**Howerton Services, PLLC**  
**License # P-1716**  
3513 Cathedral Bell Road  
Raleigh, NC 27614  
(919) 270-3460

Subject: Aviles Residence  
5675 Christian Light Road  
Fuquay Varina, NC 27526  
Harnett County Permit #: SFD1906-0026  
Foundation/Footing Inspection

S1
FOUNDATION PLAN
1/4"=1'-0"

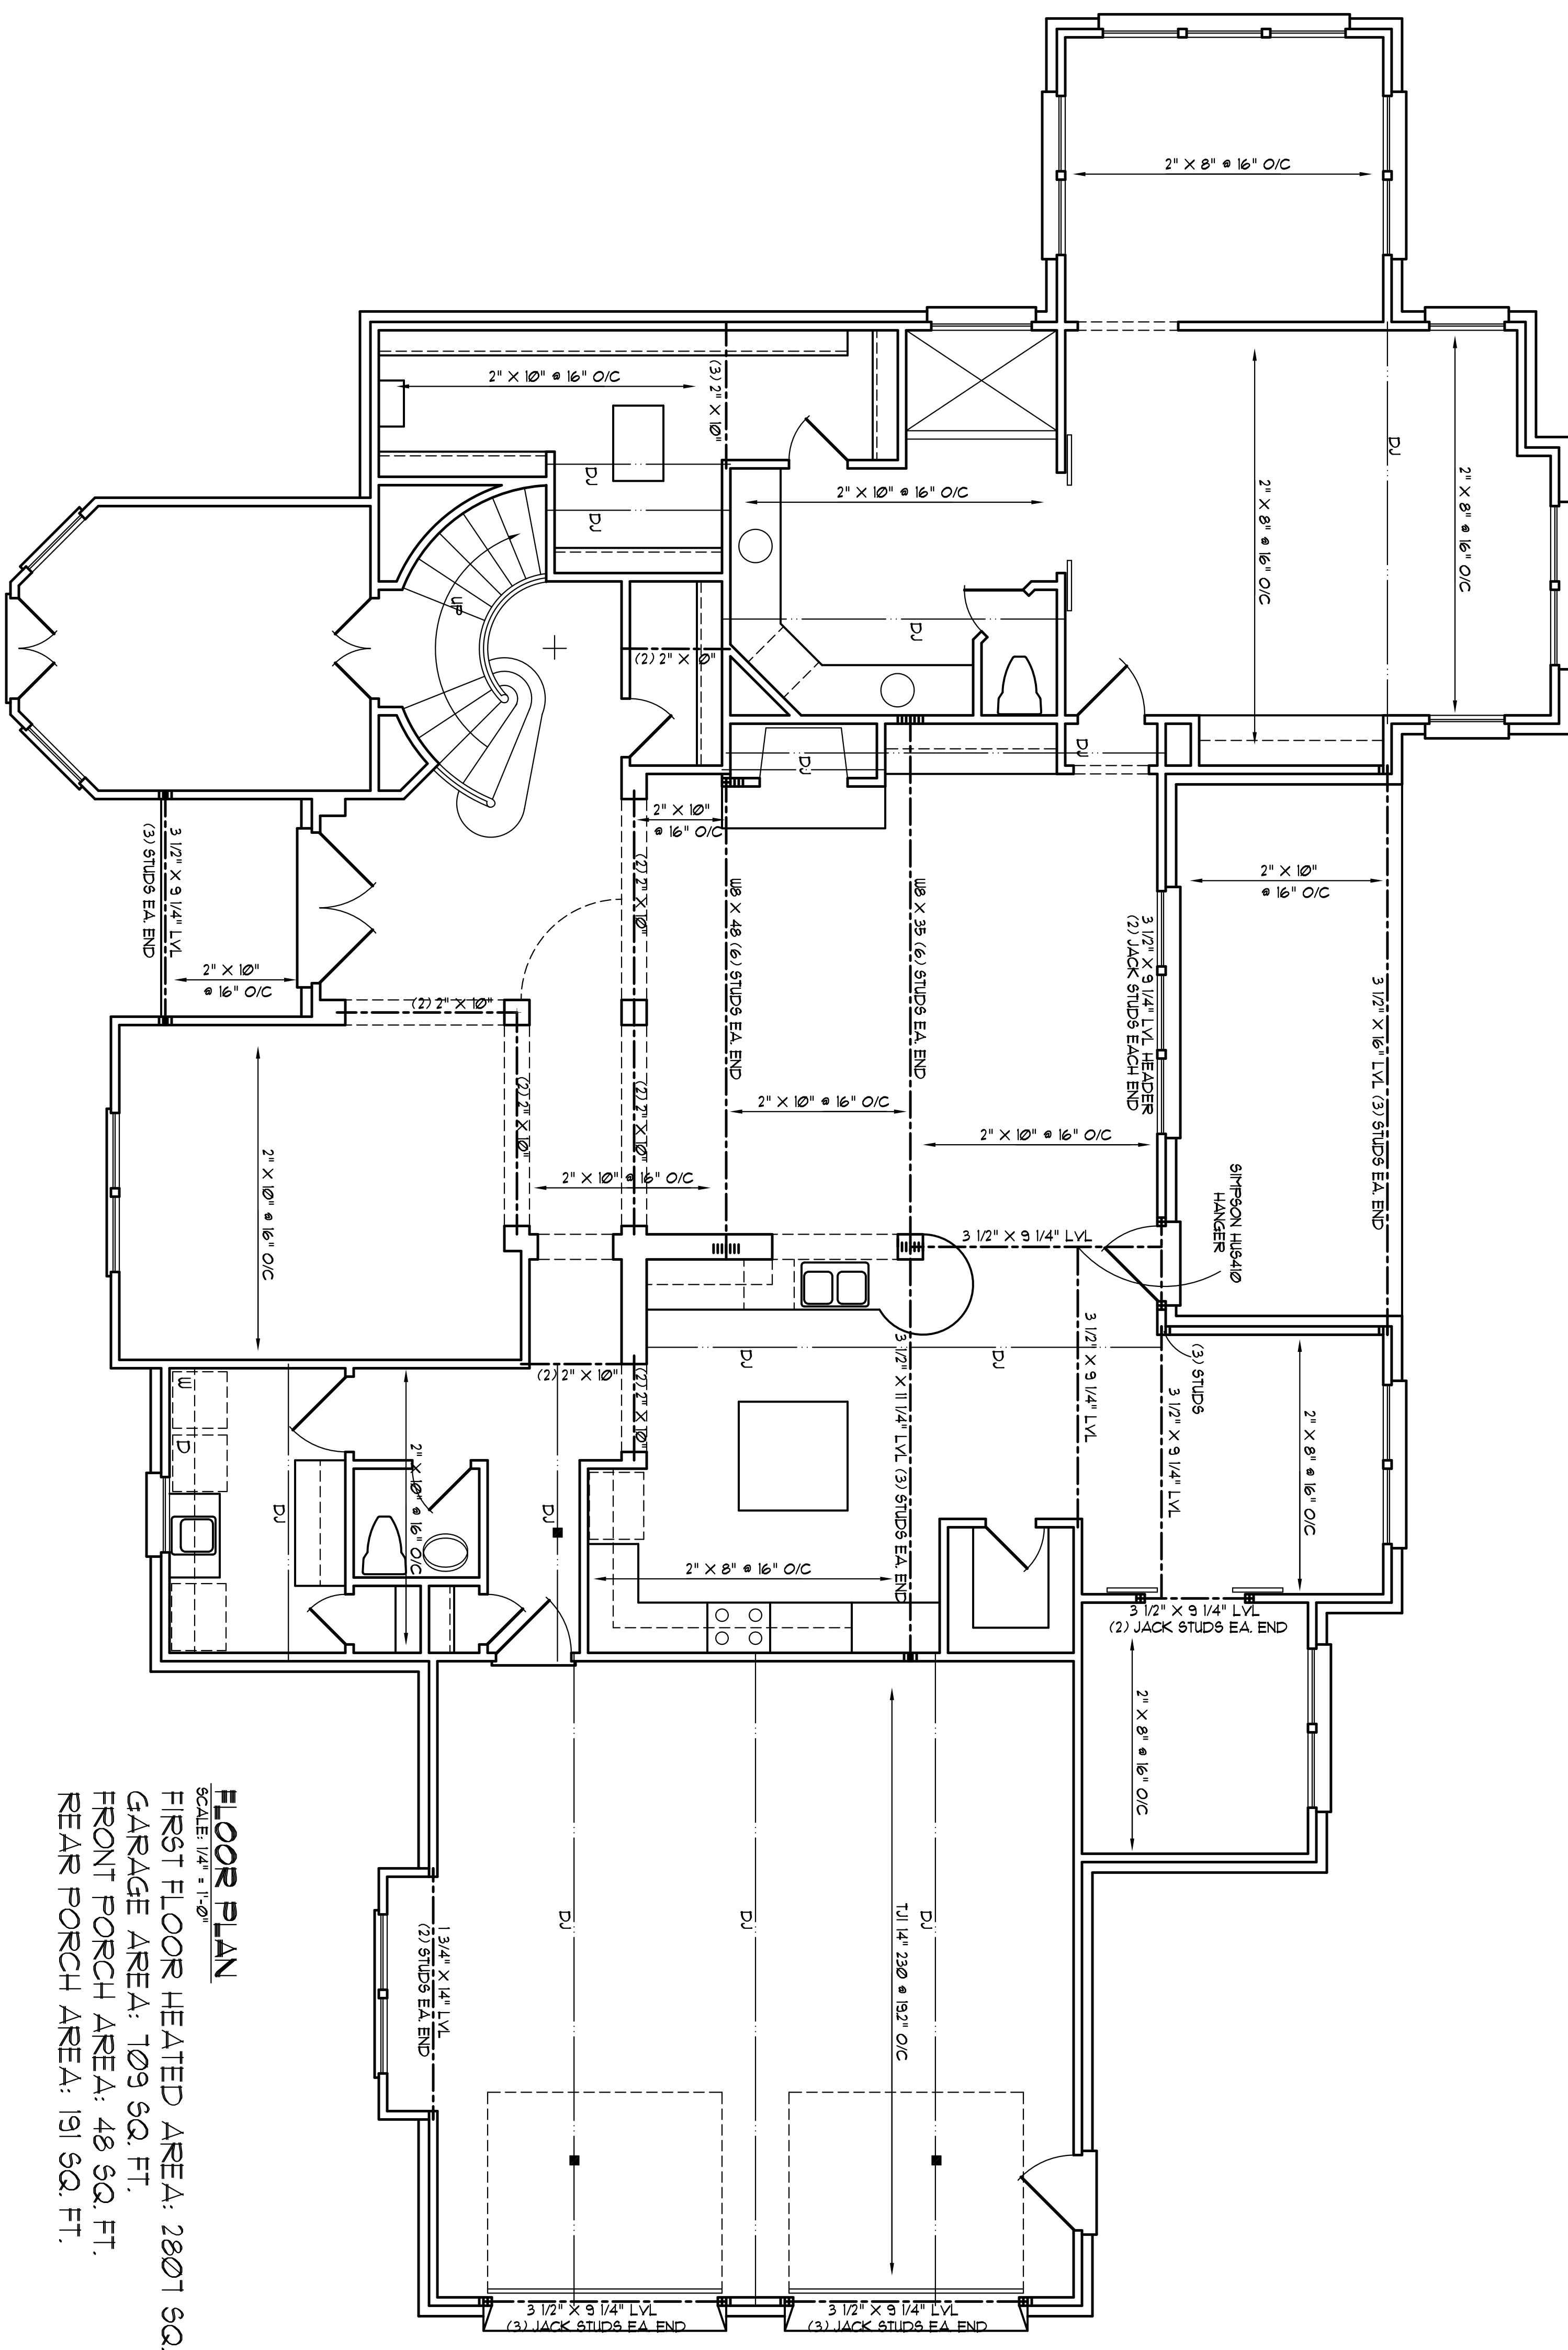
Based on the request of the inspector, I inspected the location of the foundation piers on the footings. The piers of off center of the footings in a few of the piers. Some of the piers are properly centered. The piers located off center of the footings are acceptable. The footing projections (2"-3") on the off center piers are acceptable. No repairs or additional footings are needed.

The piers and footings are acceptable and meet the requirements of the 2018 North Carolina Building Code for Residences.
